# CITY OF ALBUQUERQUE

**Re: Winrock Town Center – Phase B  
2100 Louisiana NE  
Revised Grading and Drainage Plan  
Engineer's stamp date: 7/17/17 (J19D058E)**

Based on the submittal received 7/17/17, this project cannot be approved for revised building permit until the following are addressed:

C101

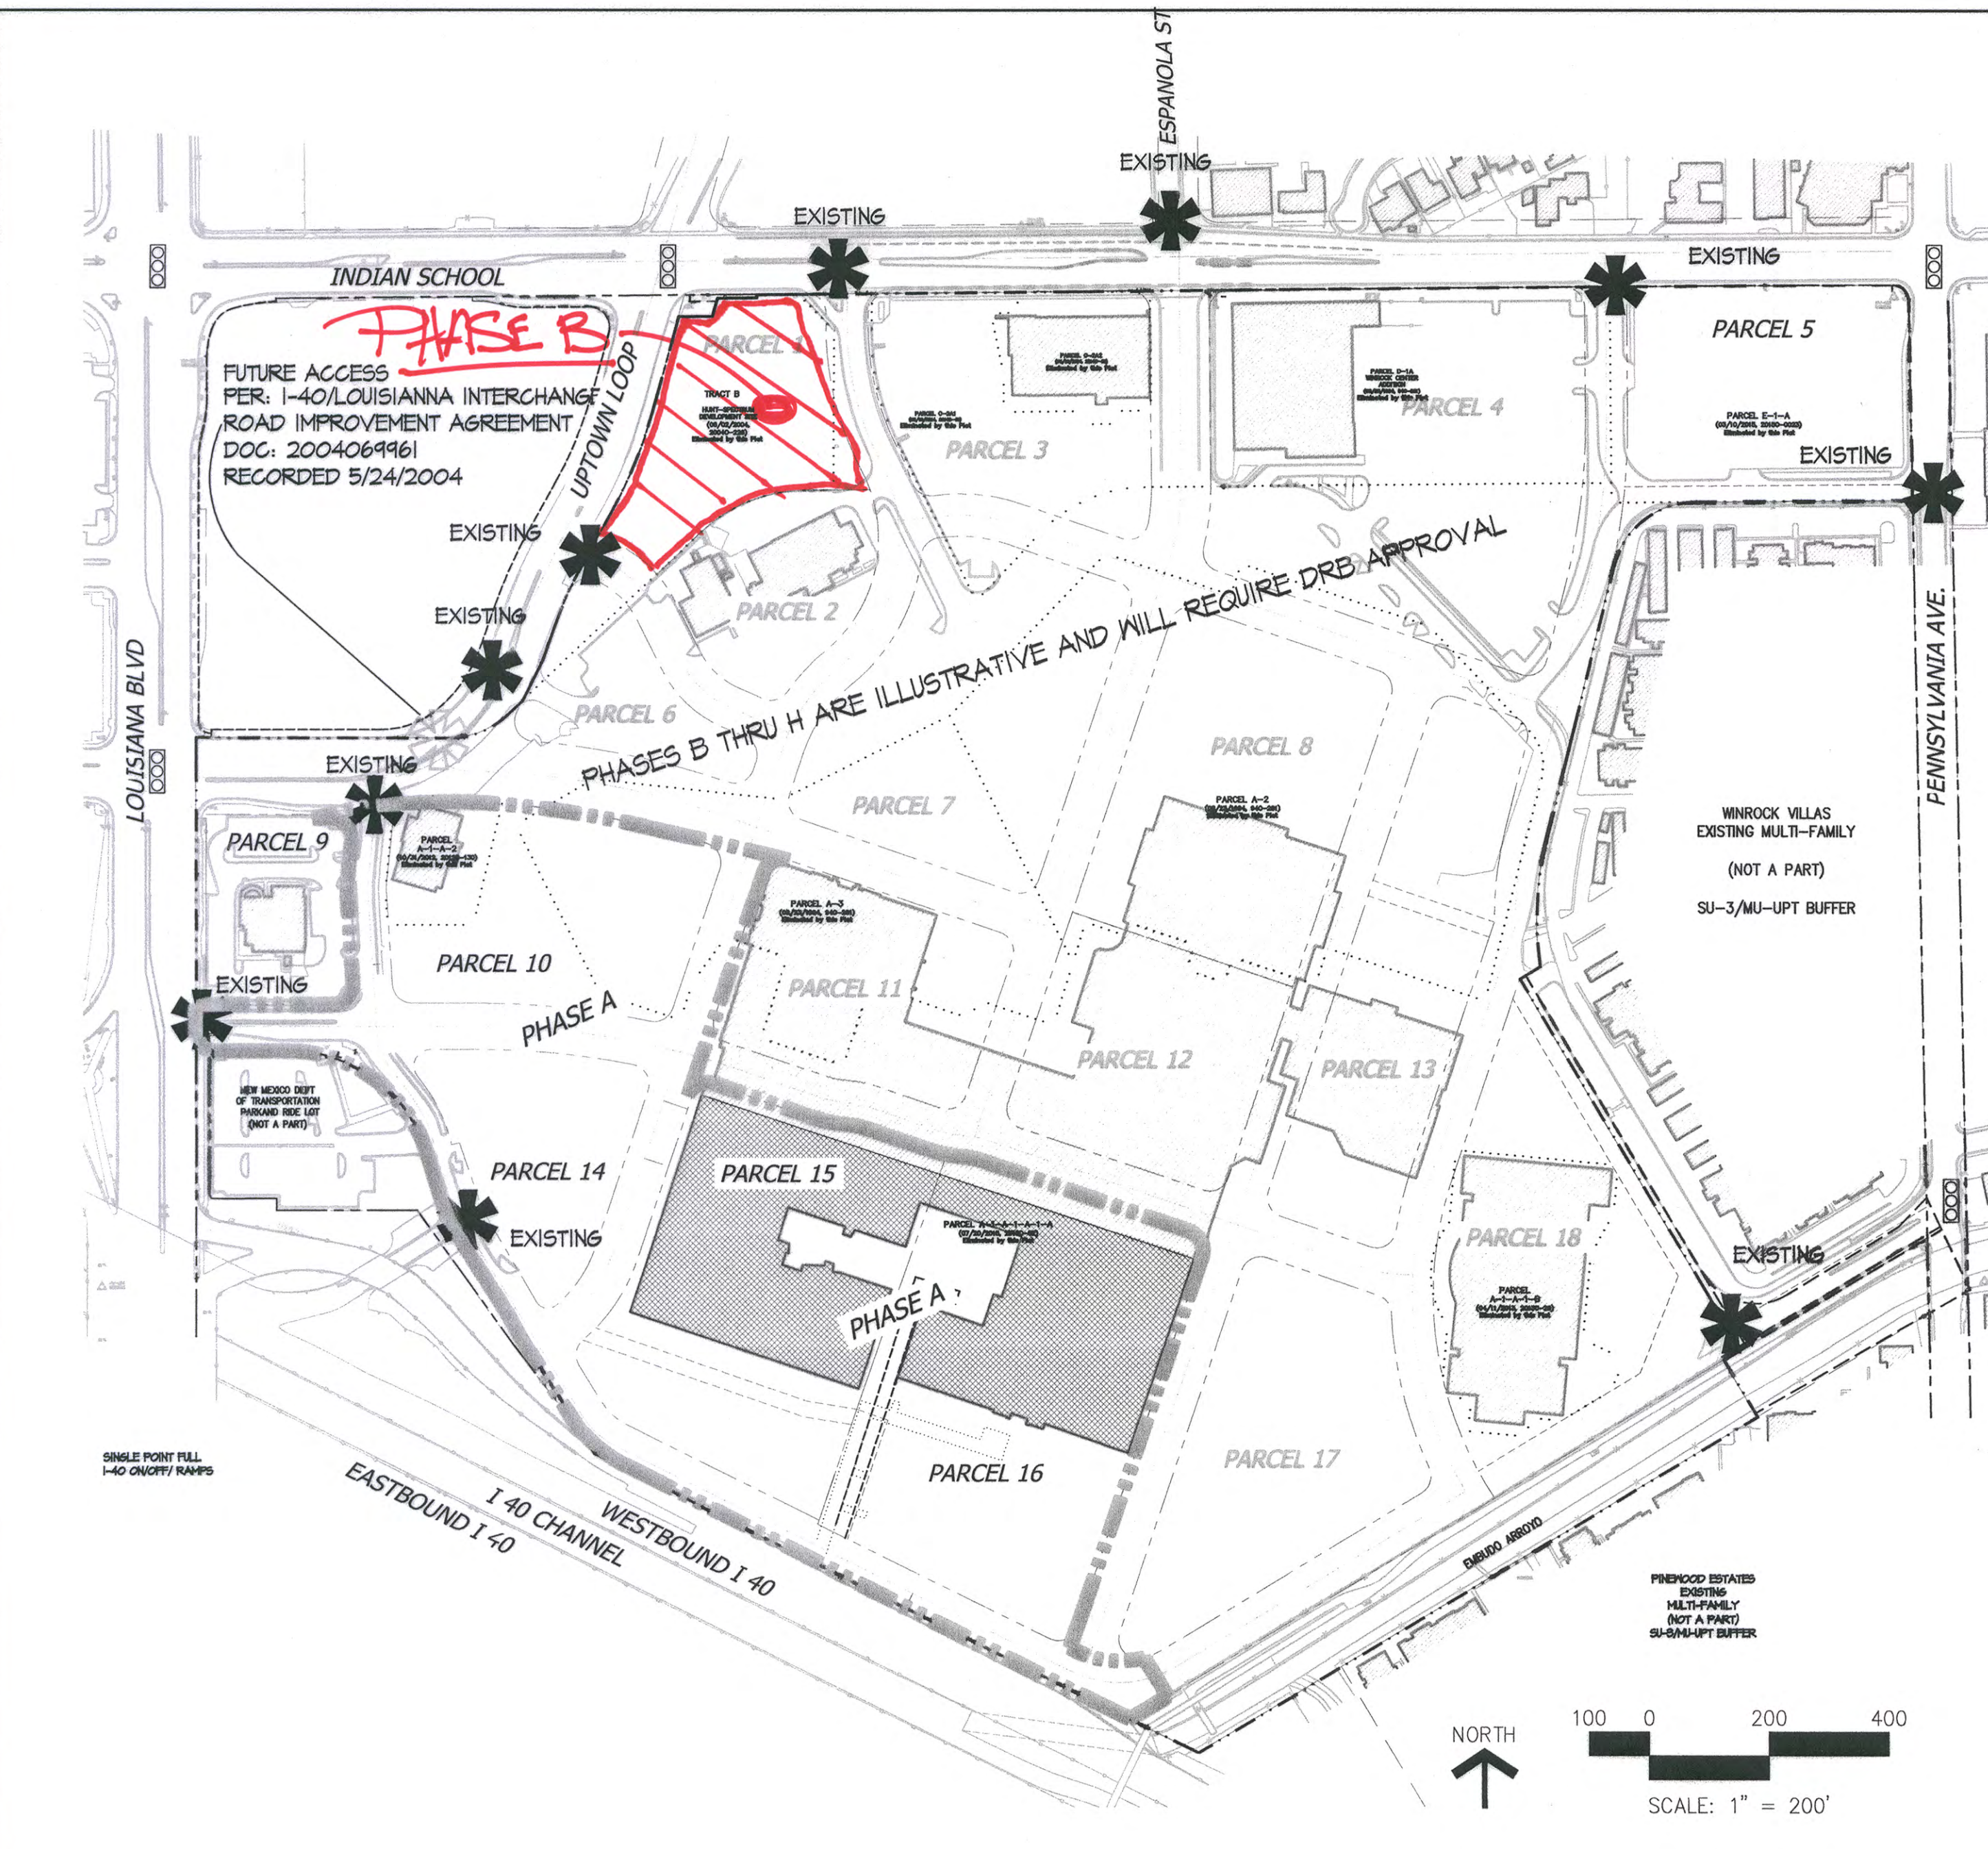
1. This grading and drainage plan needs to include all exterior improvement on the site, especially the design for draining the problem areas noted on the east side of the building at the last Hydrology inspection (6/22/17). Exterior work affecting drainage cannot be deferred to tenant improvements.
2. The rock lined channel needs to account for freeboard (see DPM Ch22.3.C.4). Also the channel slope does not match what's shown on the grading plan and a rectangular rock-lined channel does not seem constructible.
3. How does pond 2 outfall to the ROW?
4. Show the slope of all storm drain pipes on the plan.
5. Show the invert in and invert out on all inlets.
